Please ask for: Ms Iqraa Malik
Email: iqraa.malik@terraquest.co.uk
Telephone: 0121 234 1390
Our Ref: M/133/21/HH
Your Ref:
Date: 18th October 2021

Application for Planning Permission for Works or Extension to a Dwelling

Development: Erection of single storey side/rear extension
Location: 15 Old Point Middleton-On-Sea PO22 7RY

Drawing title: **Existing Plan and Elevations**

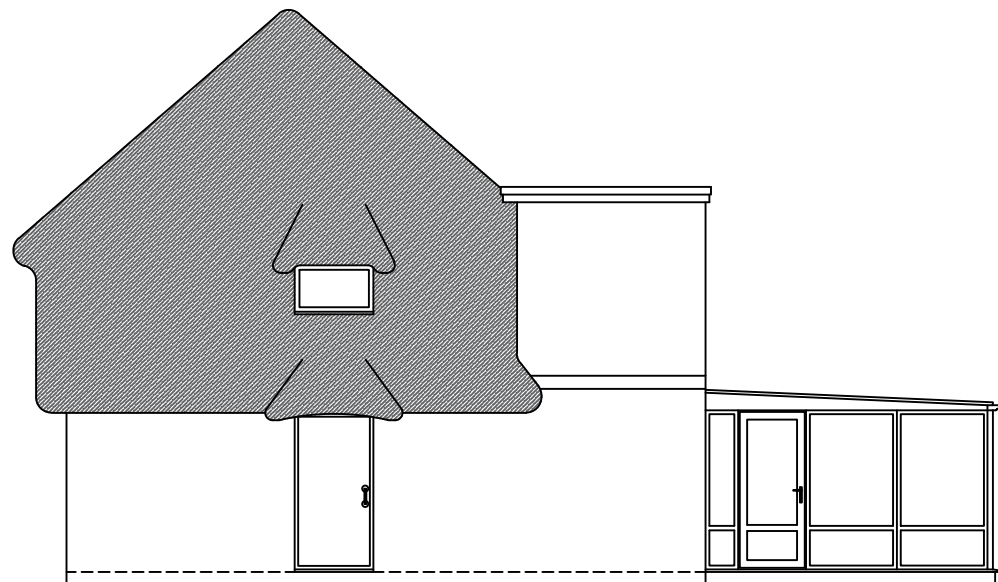
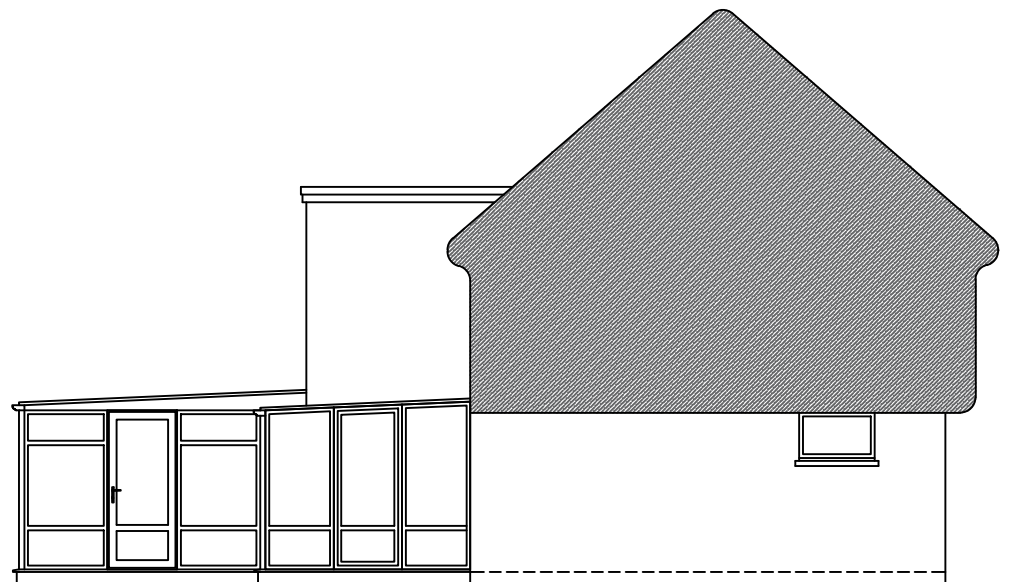
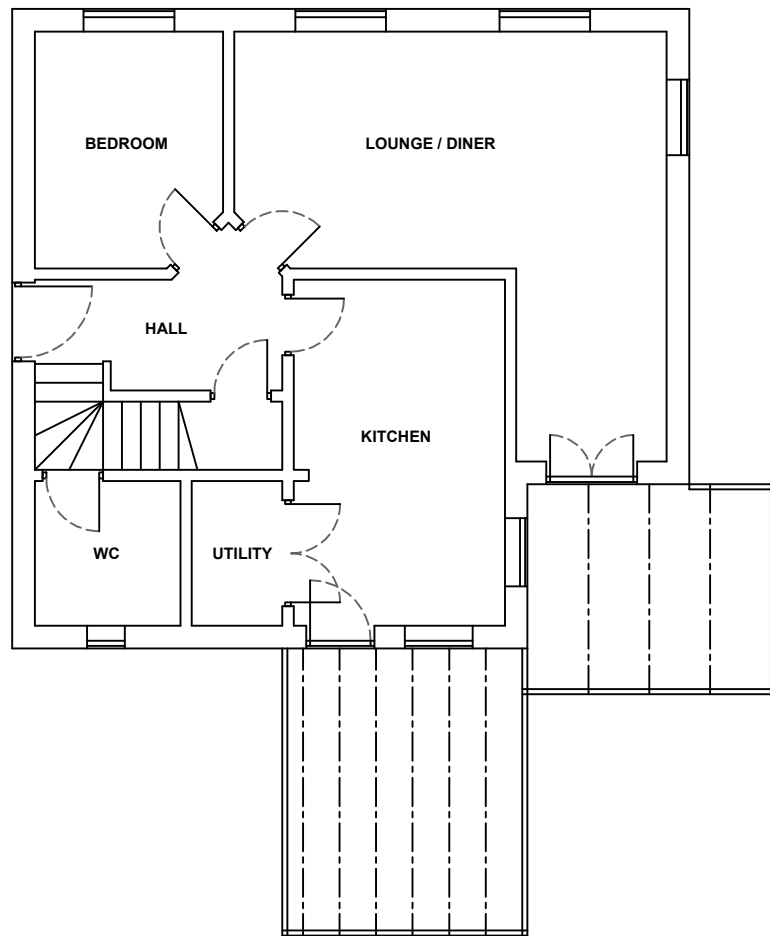
The windows and doors are inconsistent between the existing floor plans and the existing elevations. Please amend.

**15 Old Point
Bognor Regis
West Sussex
PO22 7RY**

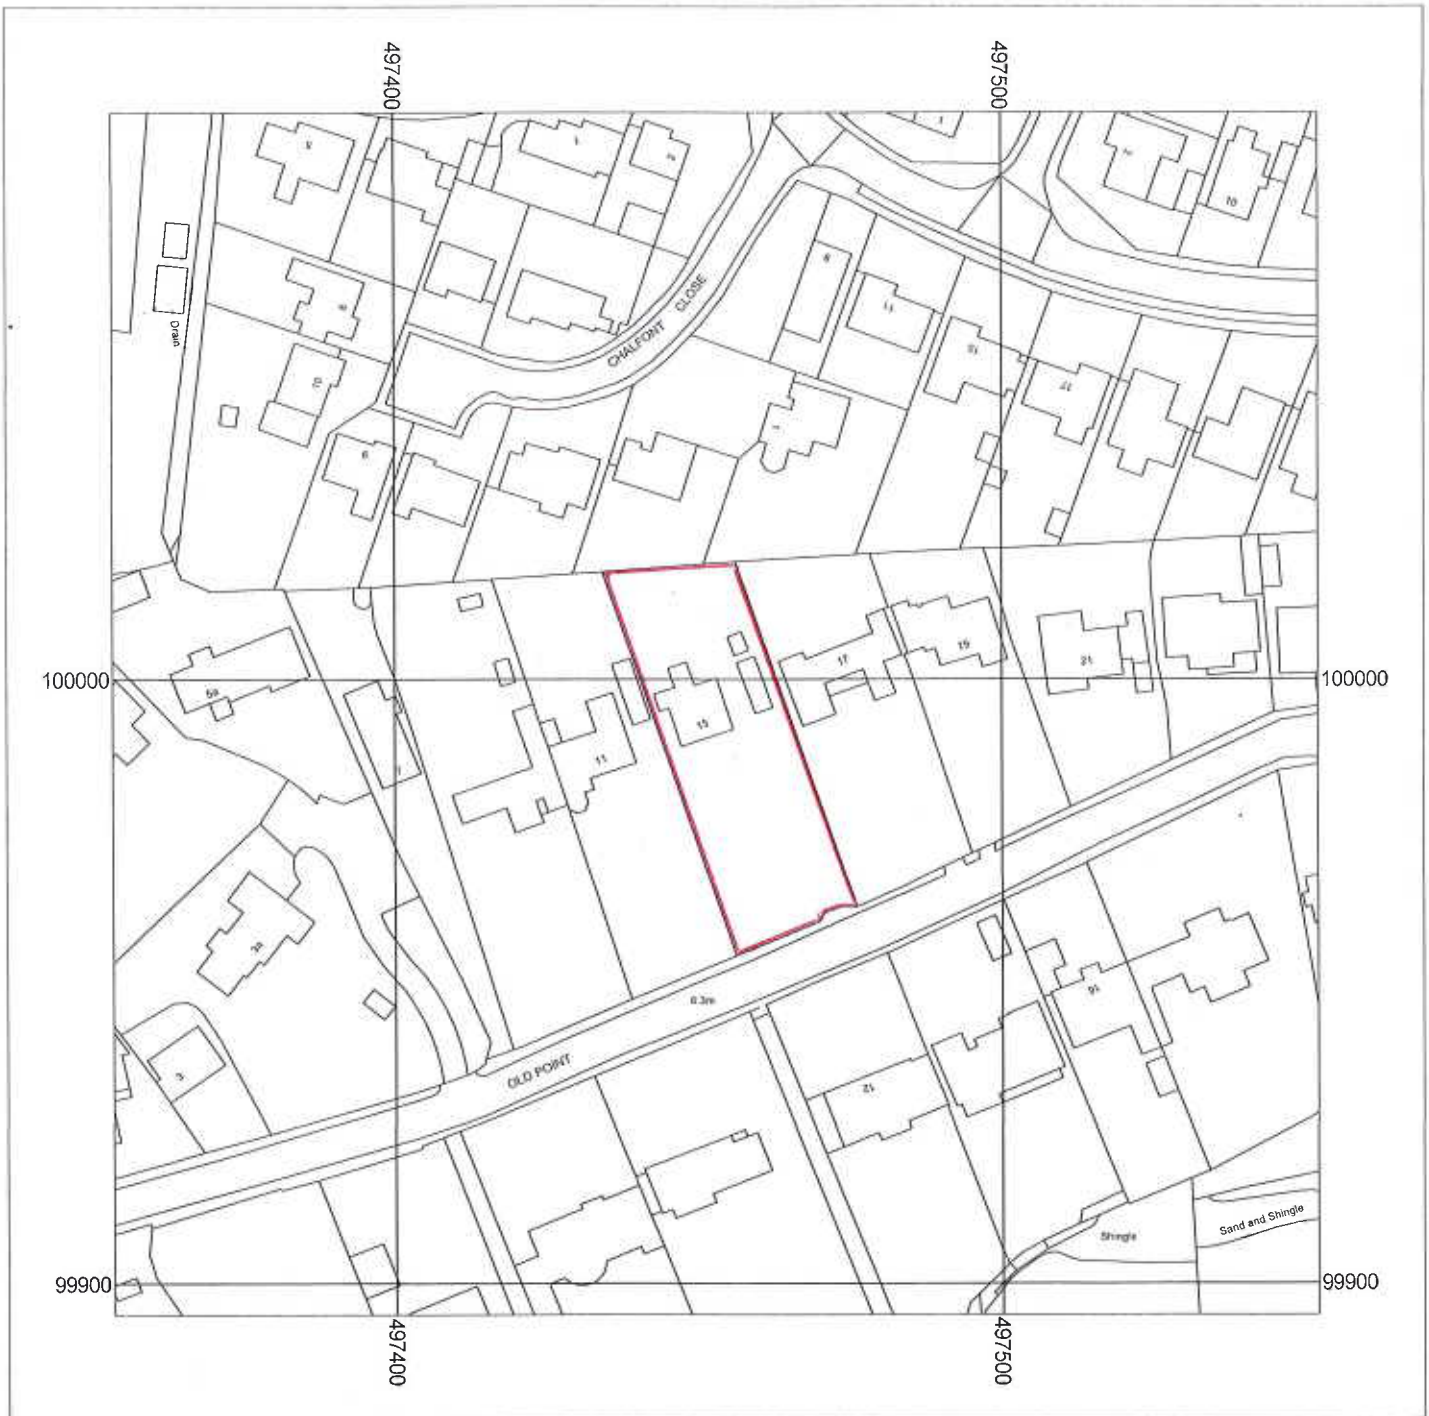
You are required to have dimensions from the proposed extension(s) to all site boundaries. Please amend.
